Mirvac Projects Pty Ltd
Level 28
200 George St
Sydney, NSW 2000Your Ref: SSD-10448
Our Ref: LTR003-01-18-596-SSDA BEW Changes
Statement
Direct phone: 02 9439 1777

RE: ASPECT INDUSTRIAL ESTATE – STATE SIGNIFICANT DEVELOPMENT APPLICATION
10448 – SSSA CHANGES STATEMENT

This letter is to provide a summary of changes made to the civil infrastructure design drawings prepared by AT&L for the State Significant Development Application for Mirvac's Aspect Industrial Estate, SSDA-10448.

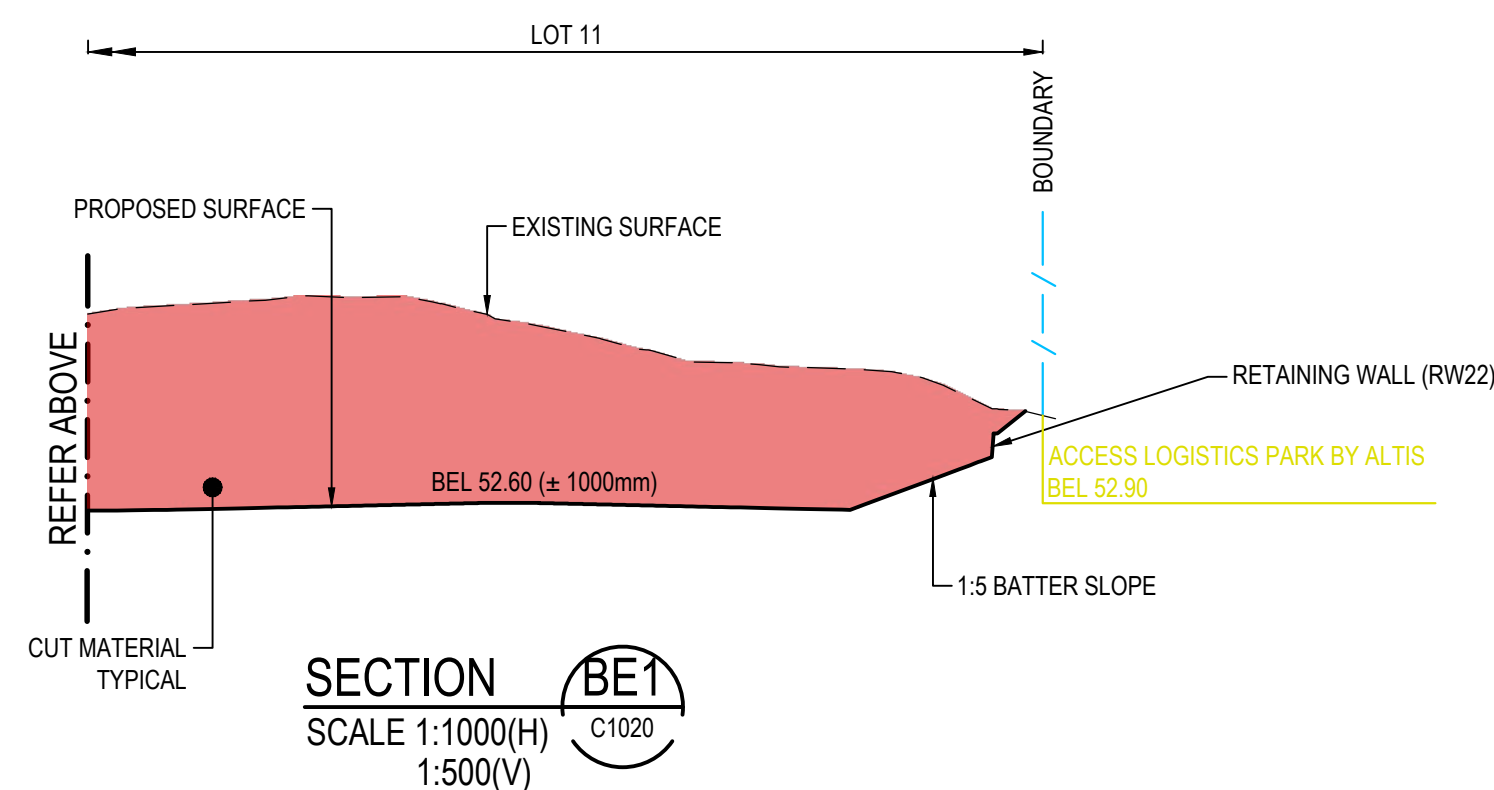
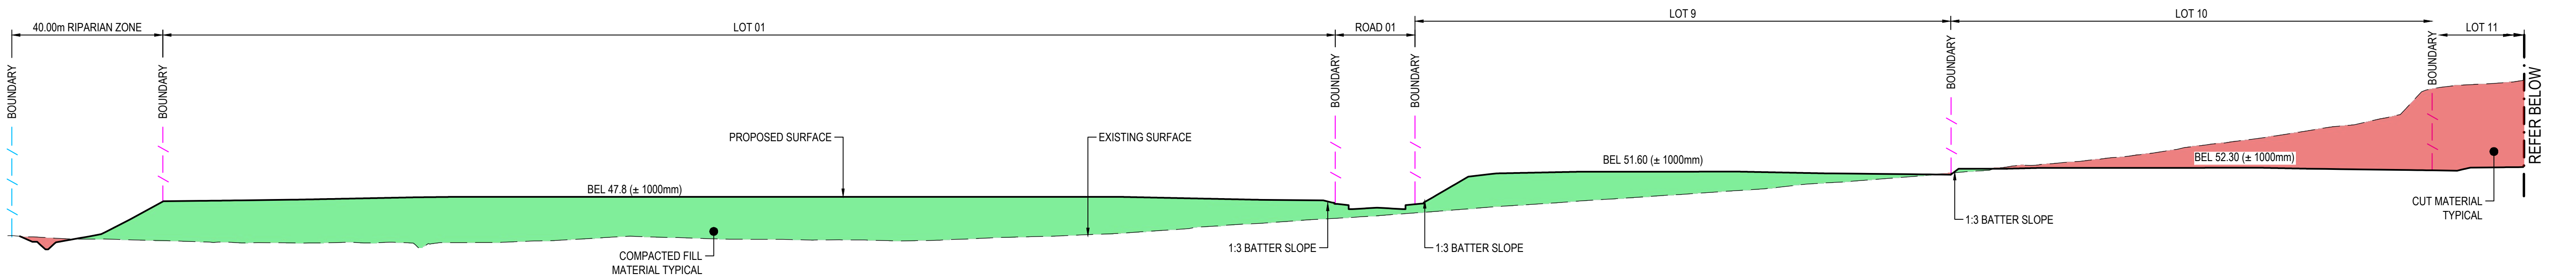
At the request of Mirvac, AT&L has undertaken a review of the bulk earthworks levels associated with the Aspect Industrial Estate. The adjustments made to bulk earthworks levels were targeted to achieve a balanced cut to fill across the site, while also taking into consideration potential future bulk earthworks levels for modifications being planned for by Mirvac. Consideration was also given to proposed bulk earthworks levels proposed by the development to the south of the Aspect Industrial Estate.

Lot	Original SSSA Bulk Earthworks Level	Proposed Revised SSSA Bulk Earthworks Level
7	56.0 +/-1m	52.6 +/-1m
9	49.0 +/-1m	51.6 +/-1m
10	54.0 +/-1m	52.3 +/-1m
11	56.0 +/-1m	52.6 +/-1m

Earthworks	Original SSDA Bulk Earthworks (m3)	Proposed Revised SSDA Bulk (m3)
Cut	711,670	1,136,085
Fill	982,152	1,130,471
Balance	270,485 (IMPORT required)	5,614 (EXCESS spoil)

The changes to the bulk earthworks design are better described by the following revised drawings:

Drawing Number	Drawing Title	Revision	Date
18-596-C1003	General Arrangement Plan	L	21-02-22
18-596-C1020	Bulk Earthworks Contour Plan	F	10-02-22
18-596-C1021	Bulk Earthworks Sections Sheet 1	H	16-02-22
18-596-C1022	Bulk Earthworks Sections Sheet 2	H	16-02-22
18-596-C1025	Bulk Earthworks Cut/Fill Plan	F	10-02-22
